Environmental Statement Consolidated Errata and Changes

National Grid (Richborough Connection Project) Order

Richborough Connection Project

Doc 5.2.1(A)

Inset 3C.1.1: Likely Roles of Environmental Project Construction Team

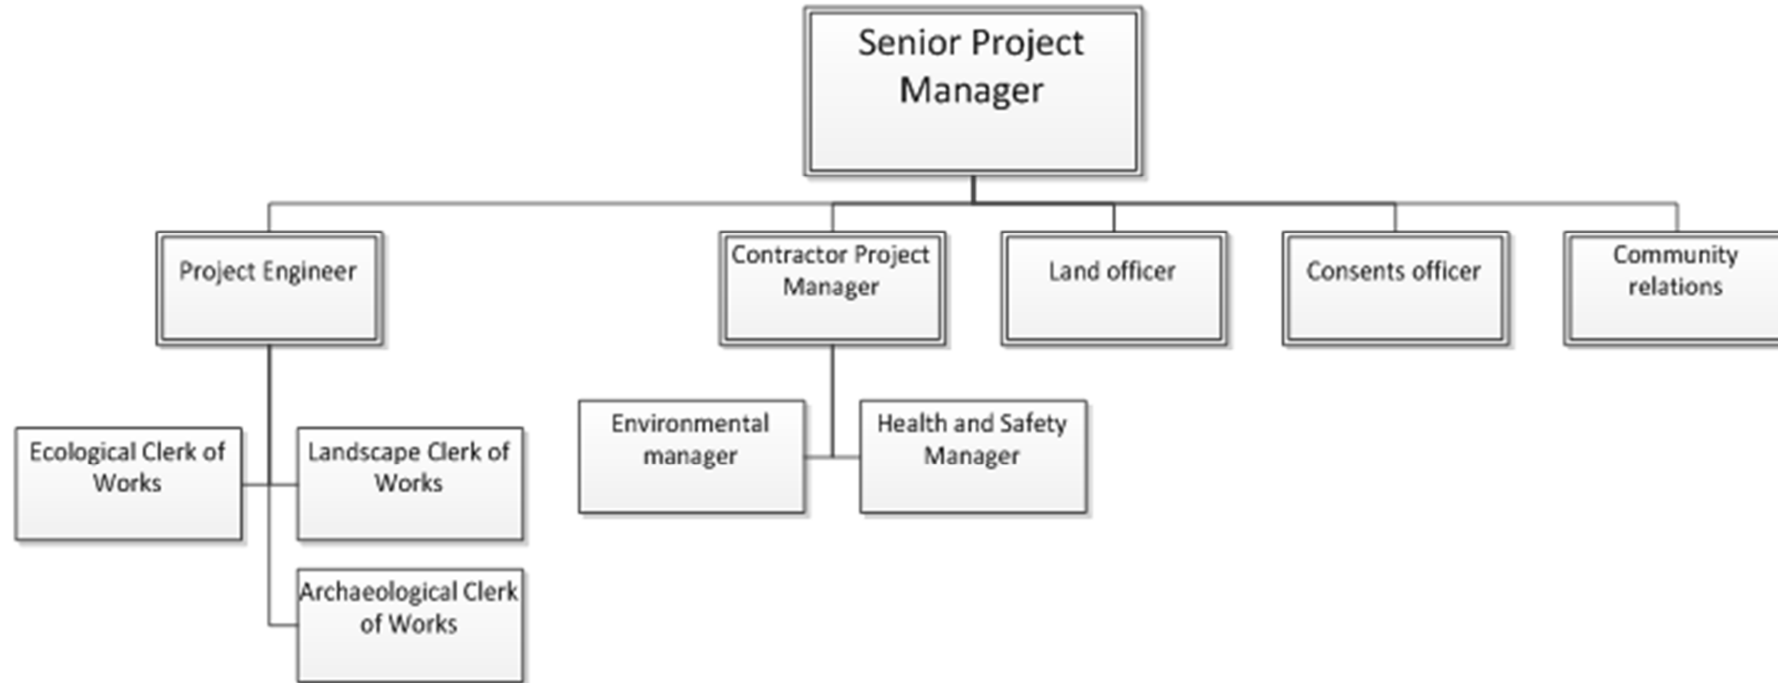
| PINS Qu. Ref | DCO Document Reference | Amendment/Clarification | Reason |
|---------------------|--|---|--|
| 2.12.15 | 5.4.3C(B) Construction Environmental Management Plan | Inset 3C.2.1 and Table 3C.2.3 have been updated to include details of the Agricultural Liaison Officer role | To respond to ExA comments in this question. |
